**Date: 15<sup>th</sup> October 2013**  
Our Ref: CPD 14042013  
Your Ref: S6/2013/1915/FP

## **TOWN AND COUNTRY PLANNING ACT 1990**

**Re: Tesco's Express, 59 Station Road, Cuffley**

Figure 1 – Proposed External Works

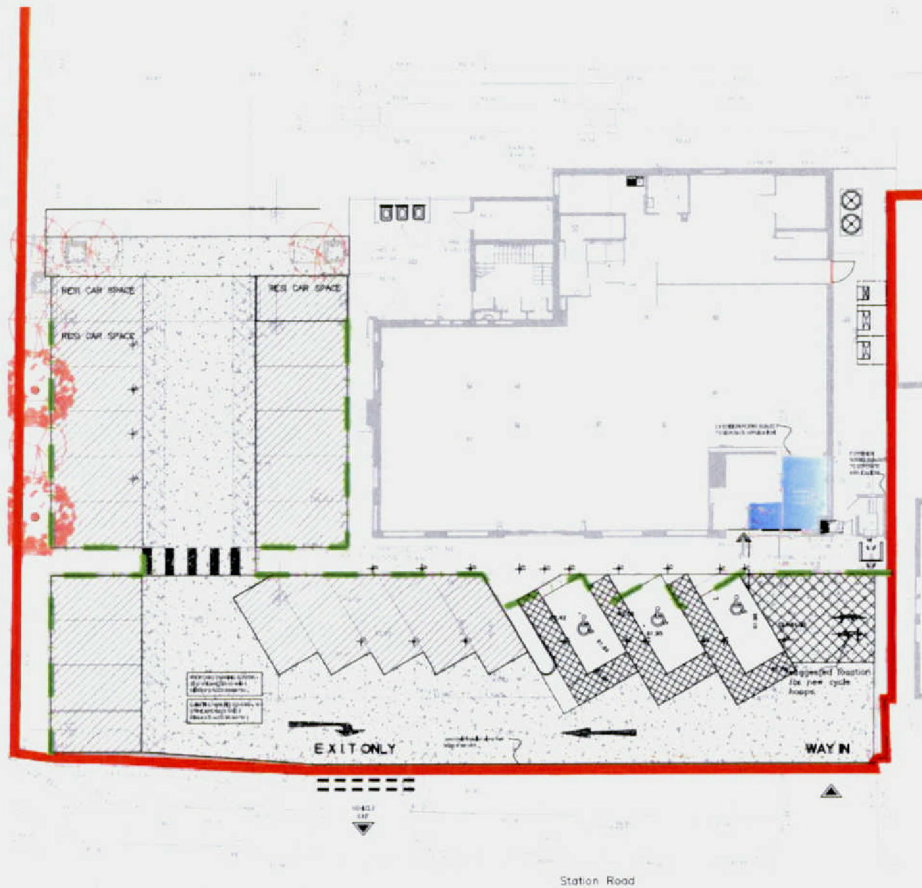
- I note that Gerry has specified bollards that are certified to the lowest standard of PAS 68; I am in agreement with him but I have substantive concerns as to whether the bollards specified on the drawing to protect the ATM are of this standard. As there is no standard or specification details given.

Unless this is clarified then the Police Design Service would not be in a position to support this application. If you have any concerns regarding these comments then please contact me.
